Our ref: OUT22/3398

3 May 2022

Subject: **Sydney Metro West - Rail infrastructure, stations, precincts and operations (Stage 3) (SSI-22765520)**

**Figure 9-19 Baseline groundwater environment – Sydney Olympic Park metro station**

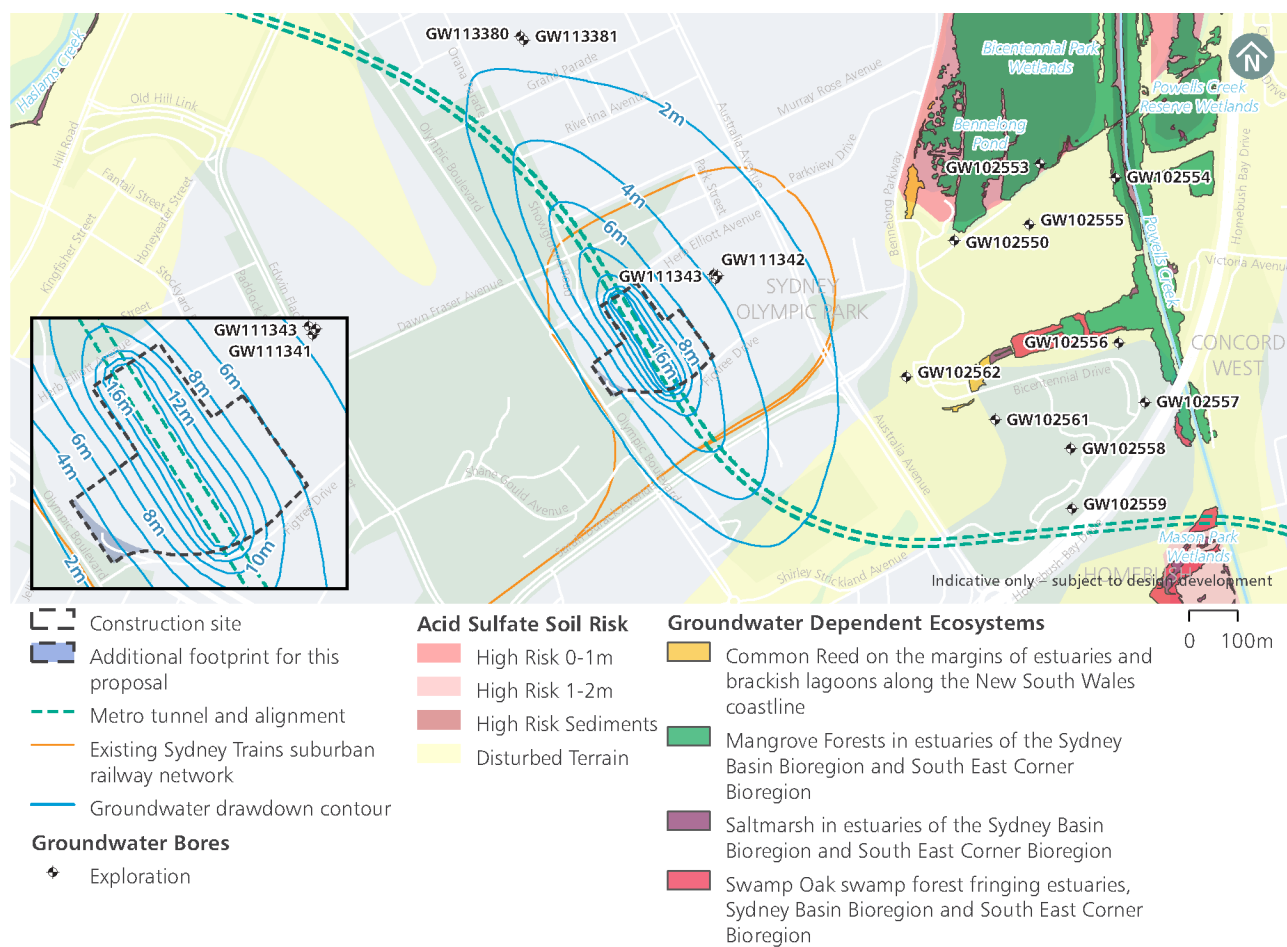
This proposal includes the operational phase of the project, including operational water take. The documentation notes for many of the stations that there will be minor to negligible impacts on groundwater. These impacts are not further quantified. Therefore, the proponent should:

- Provide more explanation as to why there will be minor to negligible impacts on groundwater and quantify the amount of take if it will be occurring.
